Consultee Comments for Application 2025/90891

Address: Land at Yew Tree Road, Birchencliffe, Huddersfield, HD2 2EQ

Proposal: Variation of conditions 1 (Plans), 2 (Materials), 6 (Landscaping), 7 (Landscape Management Plan), 14 (Ecological Design Strategy) on previous permission 2021/91933 for reserved matters application pursuant to outline permission 2018/90776 for erection of 10 dwellings

Name: Agnes Boryn- Kirklees DOCO, West Yorkshire Police

Drawing Title **Boundary Treatments Plan**

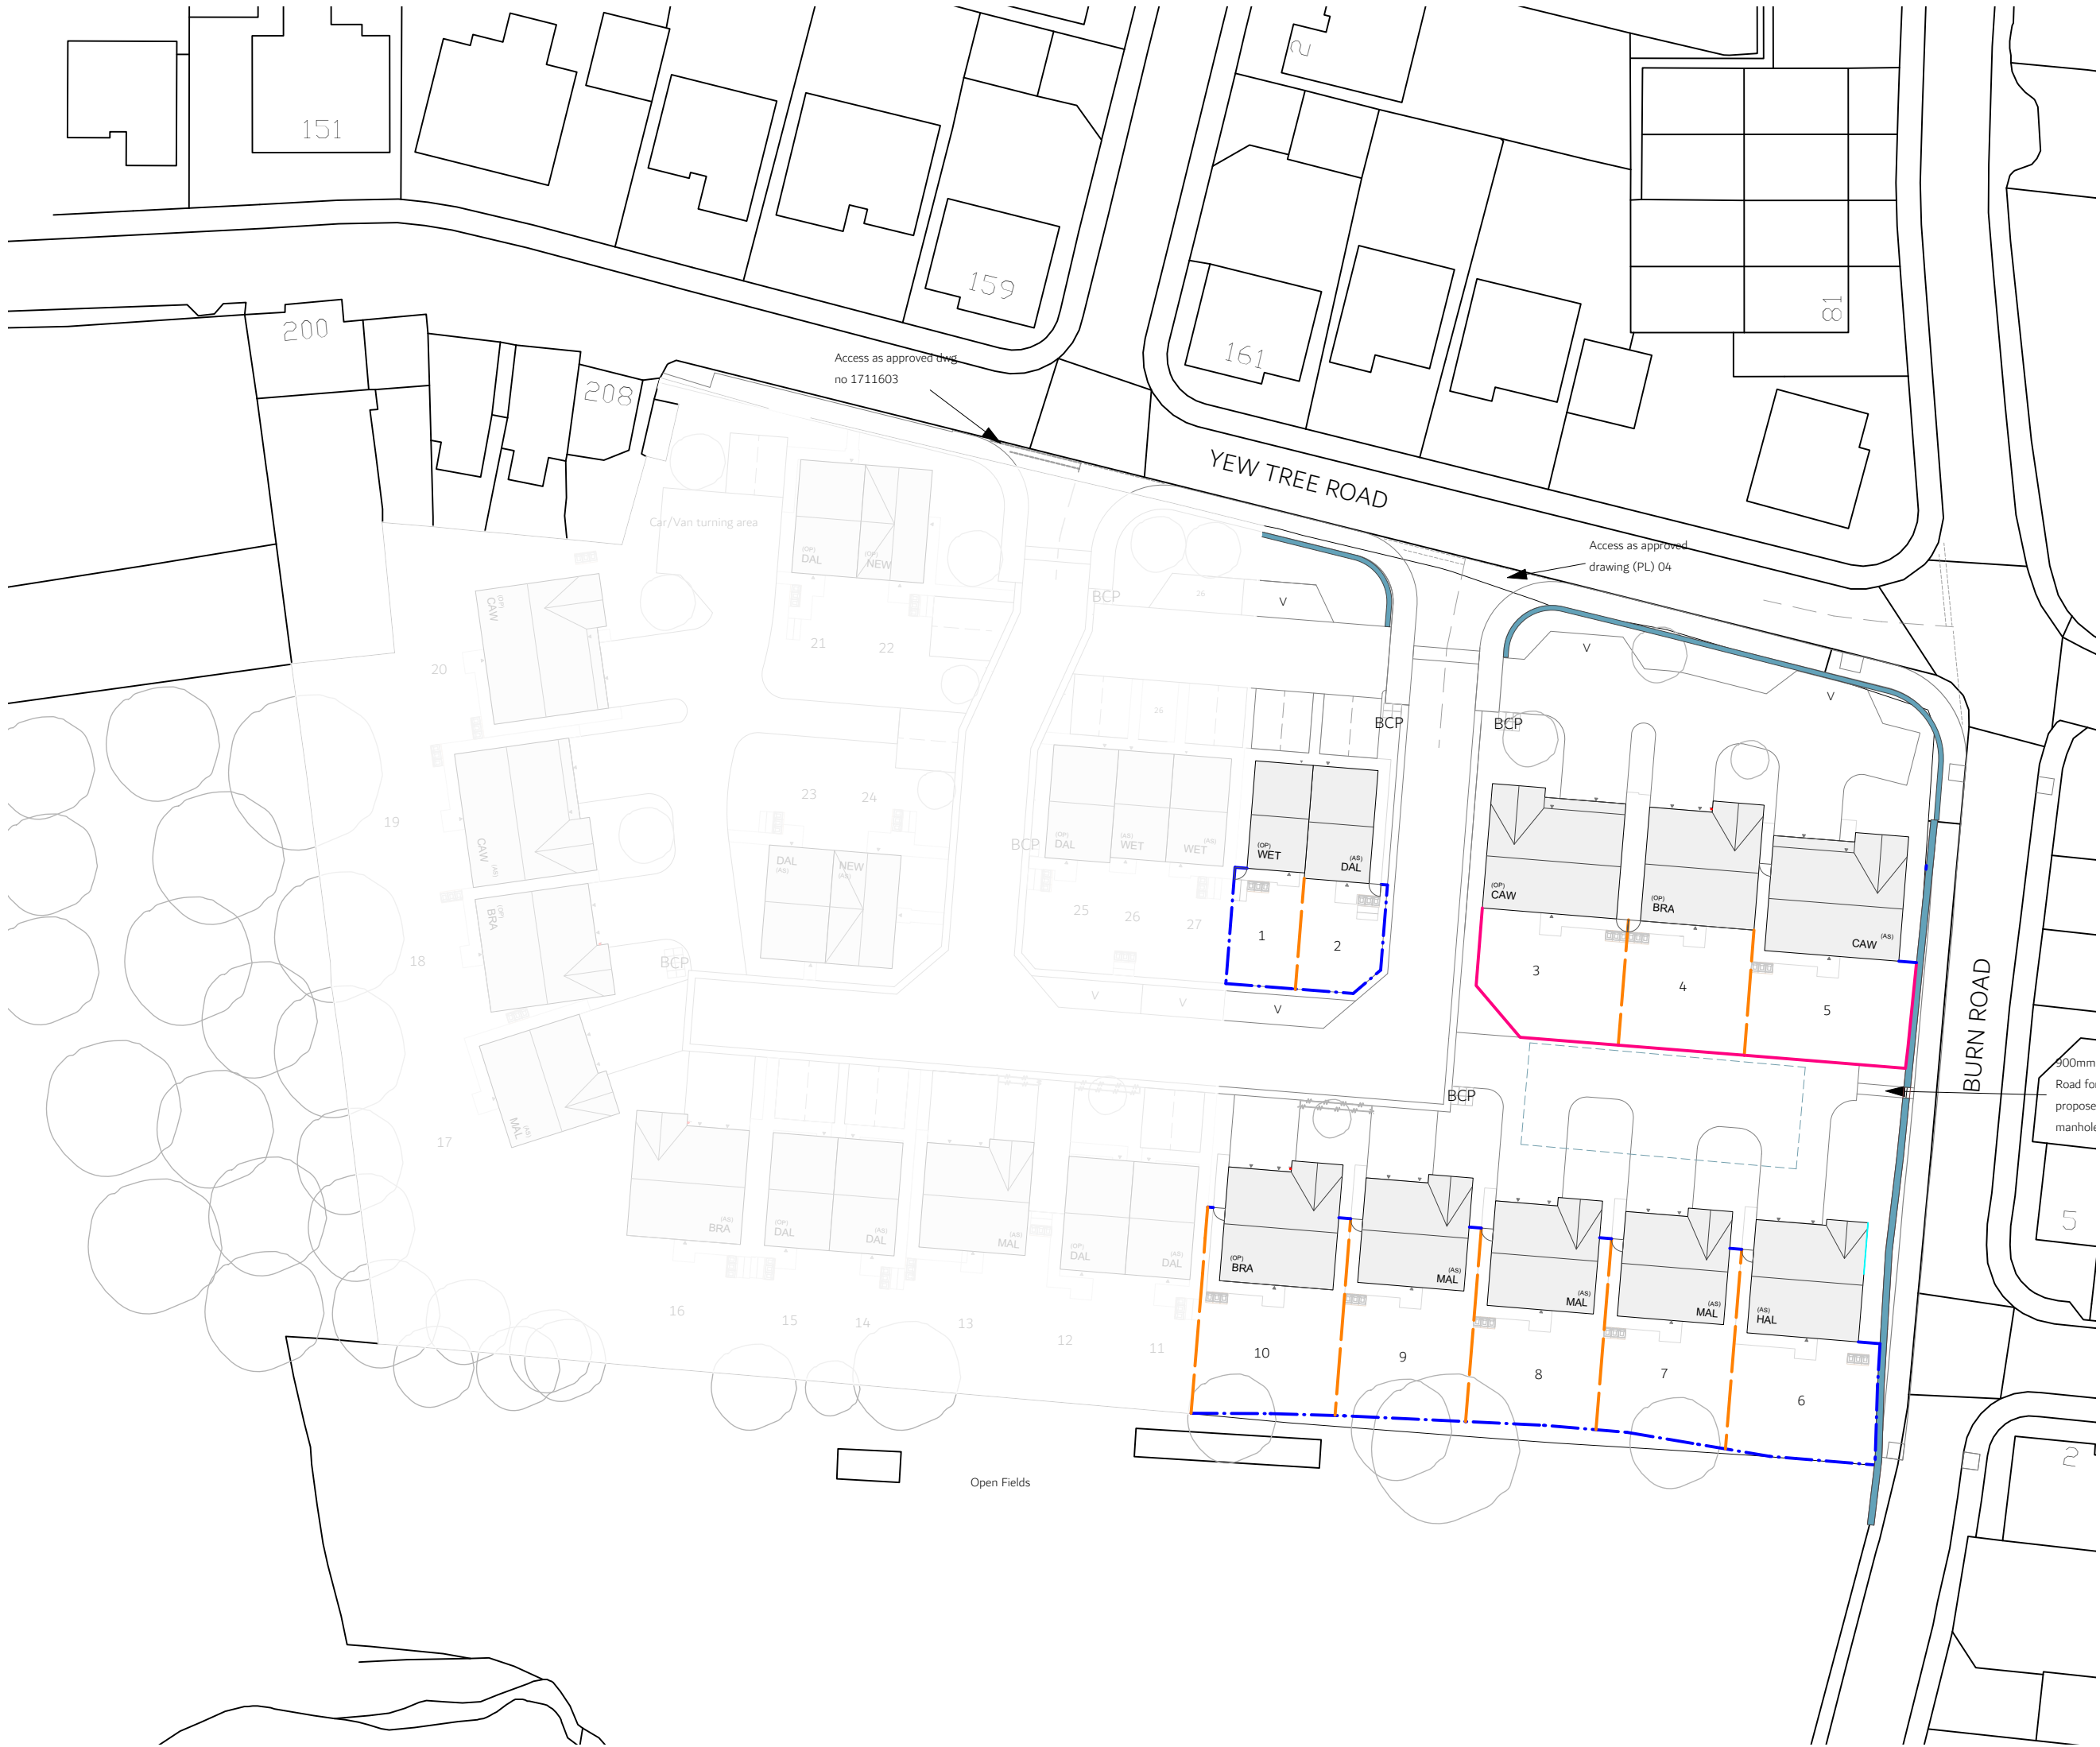
- Boundary treatments- please ensure there are no footholds on the outer face of the 1.8m fence/ wall to hinder climbing attempts or being used as informal seating.

Additionally, the subdivisional boundaries between plots (1200mm post and rail) are insufficient in terms of security or privacy. Should a single point of the 1800mm timber fence or stone wall be breached by an offender, they will benefit from a nearly unrestricted access to other plots and will be free to “garden hop” between them. Furthermore, low sub-divisional boundaries can create or add to tensions between occupiers.

The 1200mm post and rail should be replaced with either a 1800mm fence with a solid section near the building line to provide a private amenity area for the property, or a 1500mm solid fence with 300mm of trellis topping.
